From:	Billington and Langho Parish Clerk <blparishclerk@outlook.com></blparishclerk@outlook.com>
Sent:	10 April 2021 08:41
To:	Planning
Subject:	3/2021/0311
Categories:	Yellow Category

Following consultation with members of the parish council, the following objections and concerns have been reached.

Client	Brockhall Farm		
Project	Brockhall Farm redevelopment		
Title	Access mitigation		
Purpose of Issue	<input type="checkbox"/> For Information <input checked="" type="checkbox"/> Preliminary		
Drawn	AJC	Checked	AD
Scale	A4 Plot 1:500	Date	7/1/2021
Drawing No.	J1194 access fig 2	Rev

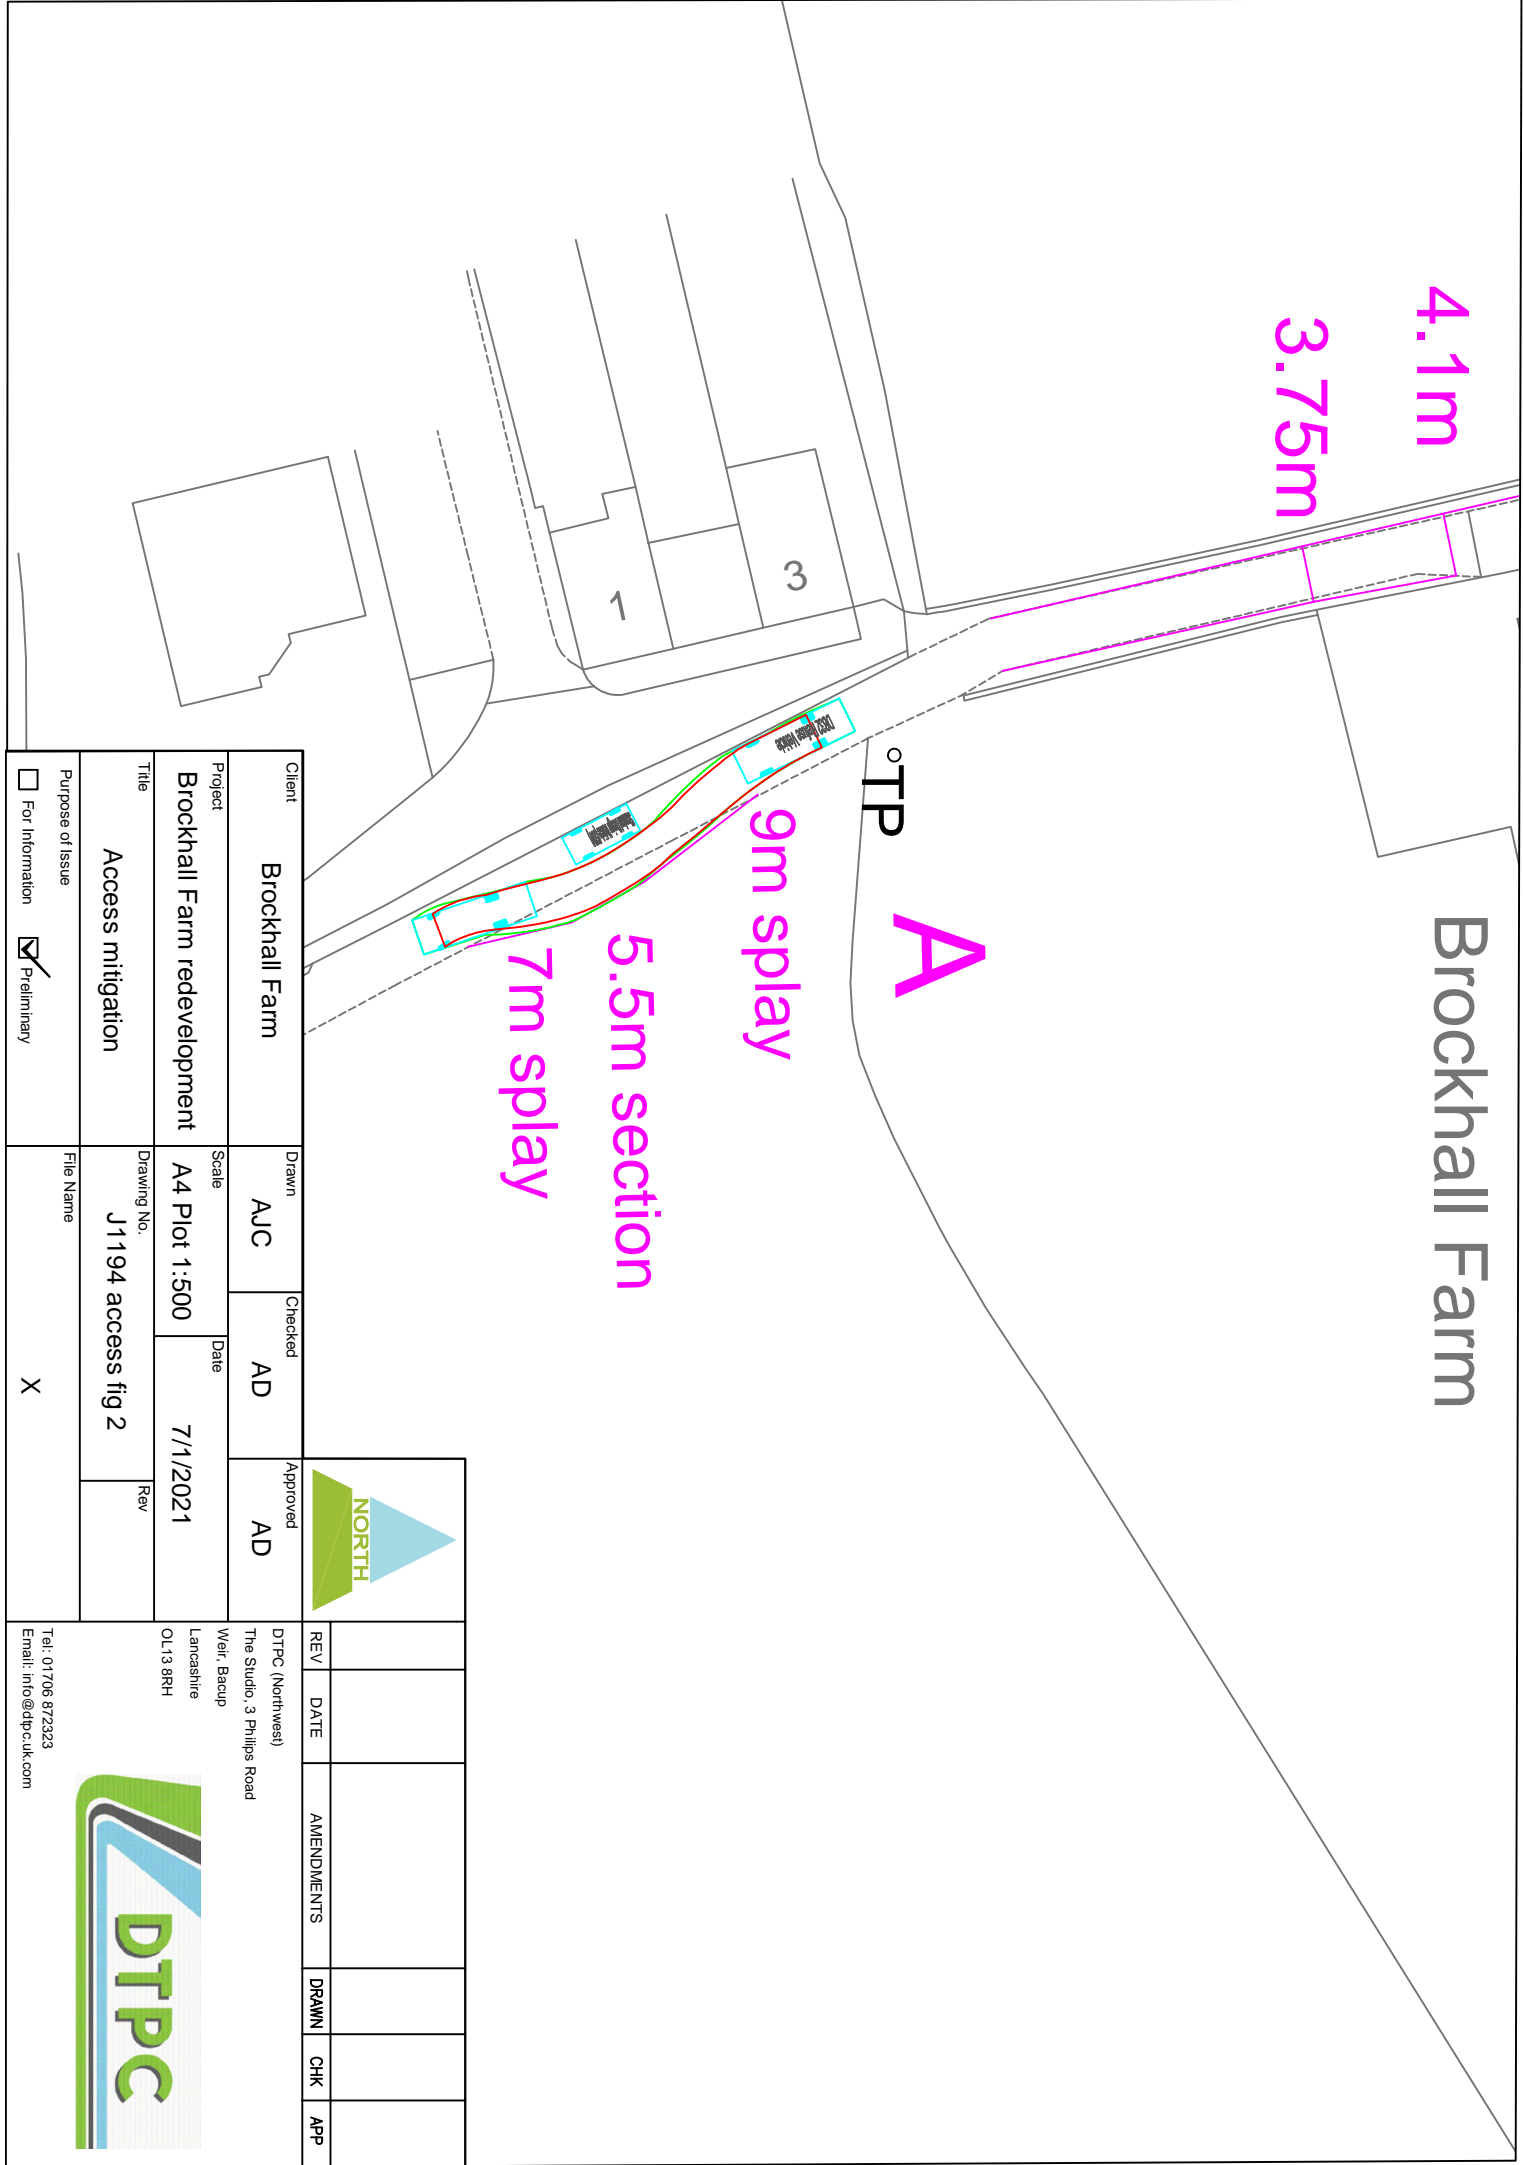
- The road is very narrow and will not be helped by parking.
- concerns mainly with the access to and from site. We note that an effort has been made for
 passing places on their land, however once passed the cattle grid there is no place a car
 can pass until it is on Old Langho Road, a good distance on a private unadopted road,
 shared with the farmer and Larkhill Maintenance Ltd which floods at the bottom end of
 Larkhill cottages in bad weather

- The state of this road is poor due to slippage into the field by wagons. We note in the application it states there is a 20-speed limit this is incorrect the parish council tried to change this to 20mph but RVBC turned this down. The speed limit on that road is 30mph.

- This access to the site should be deemed unsuitable. Another access through Gleneagles Drive, that was blocked off in the past, would have been better suited. The applicant has not consulted Larkhill Maintenance about using the private road for other than farm traffic which is minimal and the state of the road is not really fit for current usage. As children always play in this area on bikes and on foot it's disappointing no consideration of increasing traffic takes this into account.

# PROPOSED DRAINAGE LAYOUT

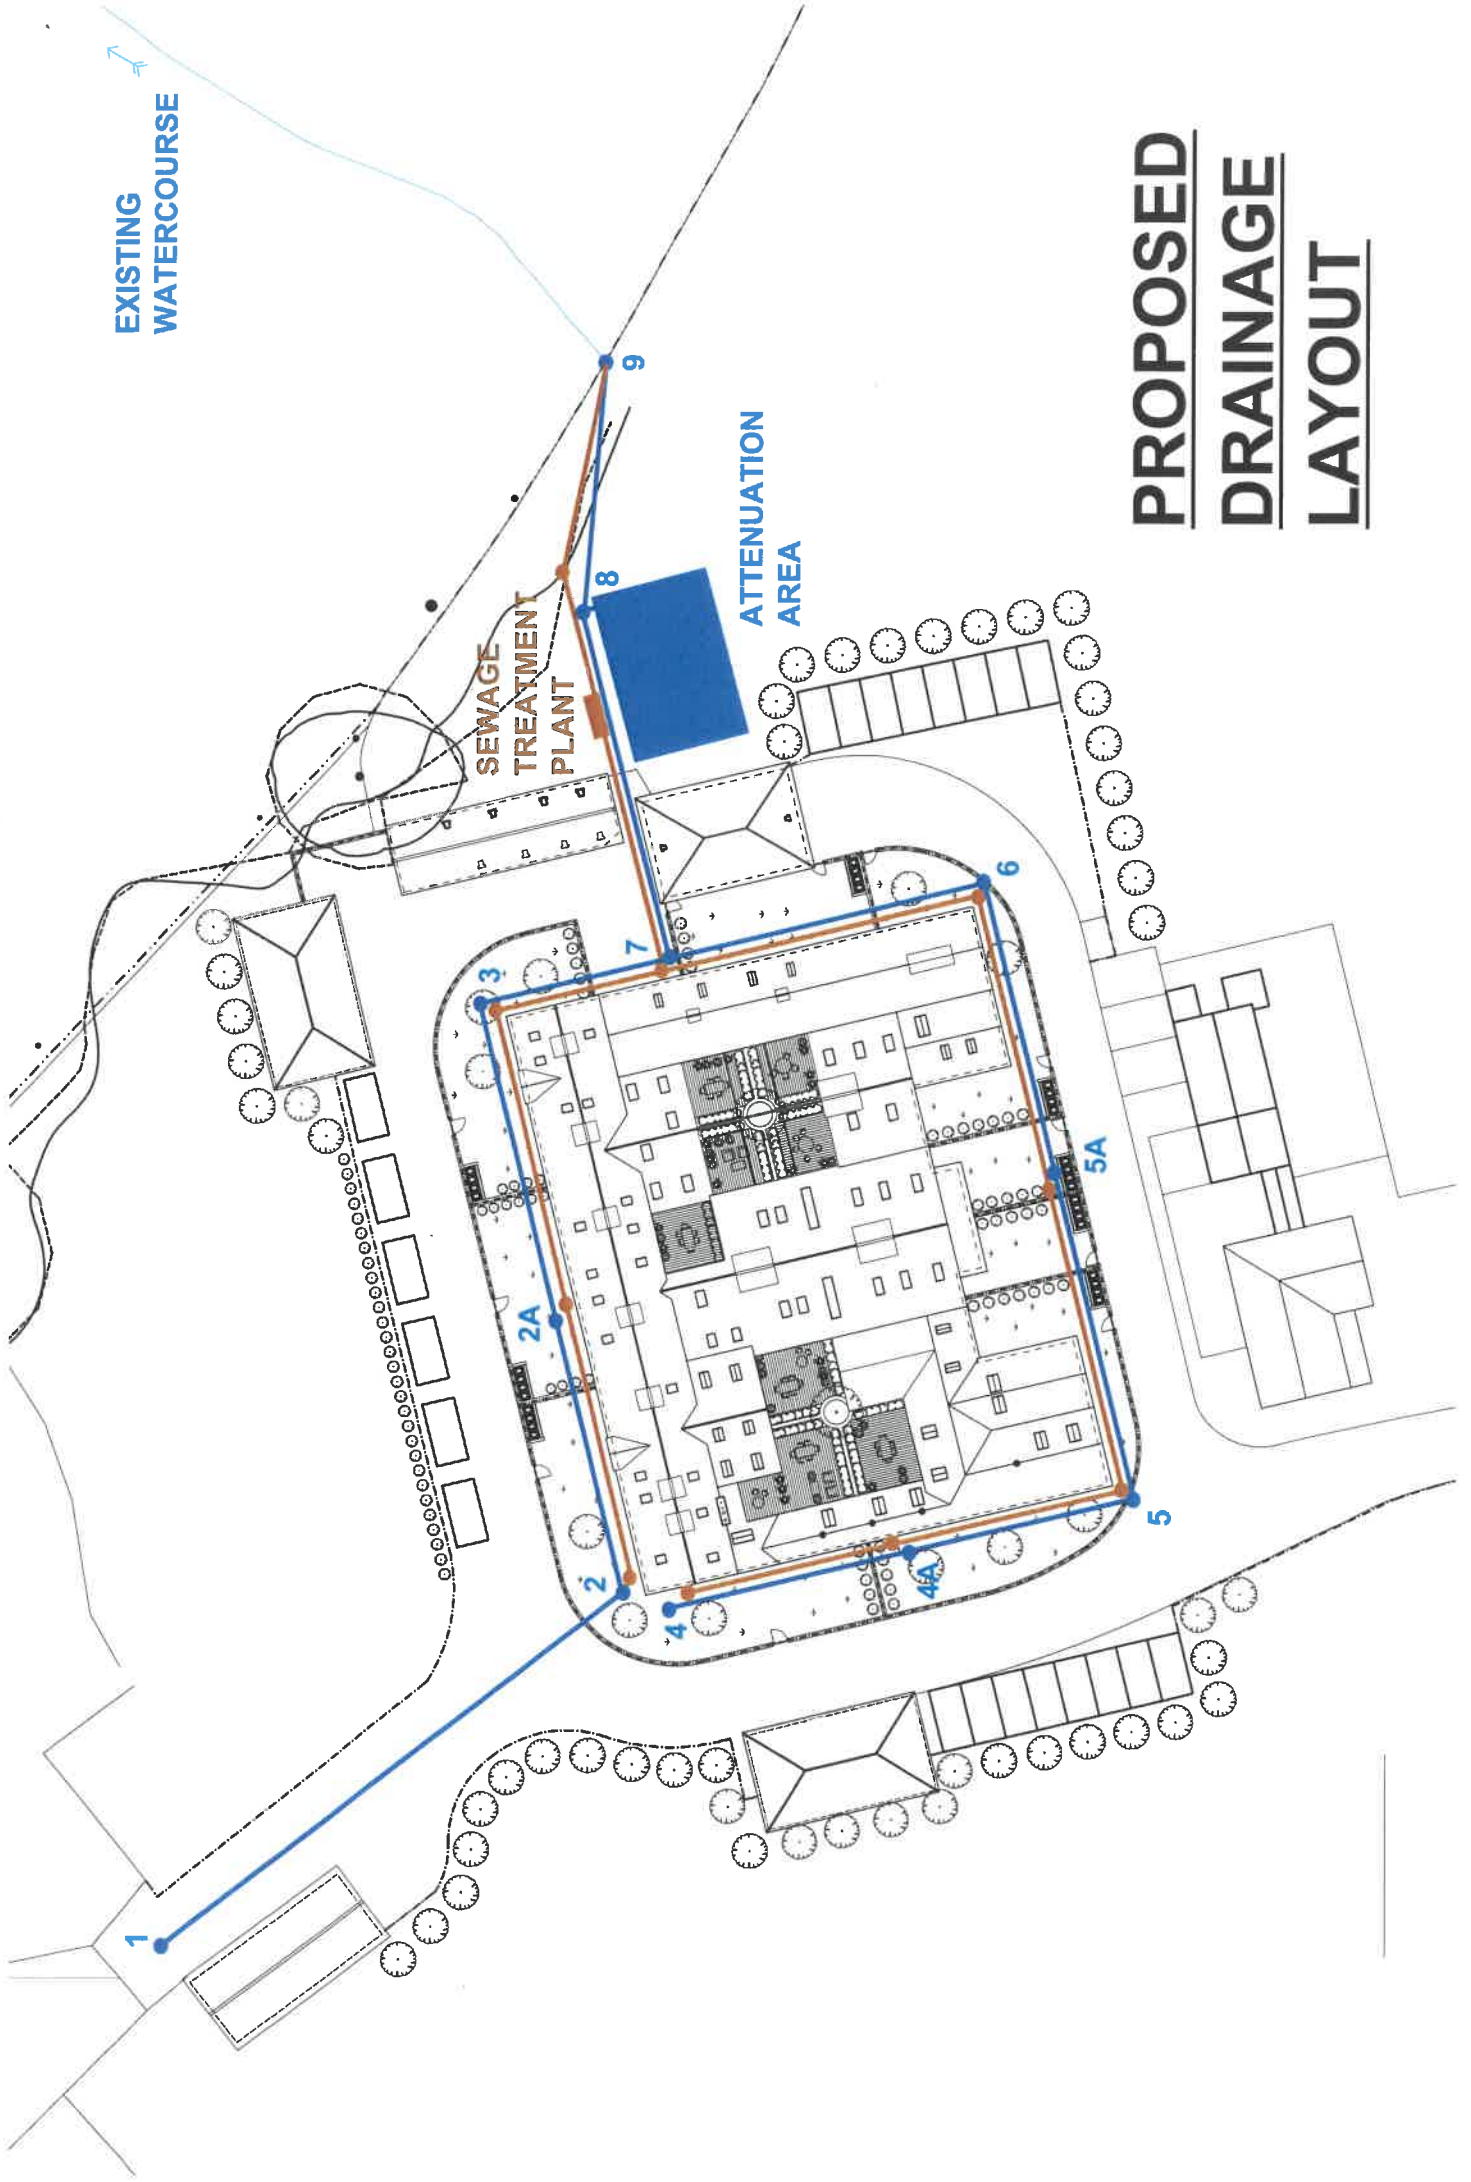
The drainage report says that the brownfield run-off rate is 6.2 l/sec, which based on the site size of 0.6 hectares gives an extended rate by area of 10.3 l/sec/hectare. The report says that the development will aim to keep this flow-rate unchanged – it seems high on the basis that a normal rate would be expected to be around 5 l/sec/hectare and they are planning to put more buildings on the site than before and run the water into the river. Though it is only 8 houses and the L.C.C. rules say 10 as a minimum.

It is requested that the Borough Council please consult with the LLFA to make sure this is ok?

There is not a serious sewage treatment plant at the site currently – it is believed that the sewage from the existing 2 houses joins the main sewer that runs away from the river. It is requested that the Borough Council please alert United Utilities to the proposed sewage

treatment plant before effluent is put in the river and ask them to look at the proposal carefully?
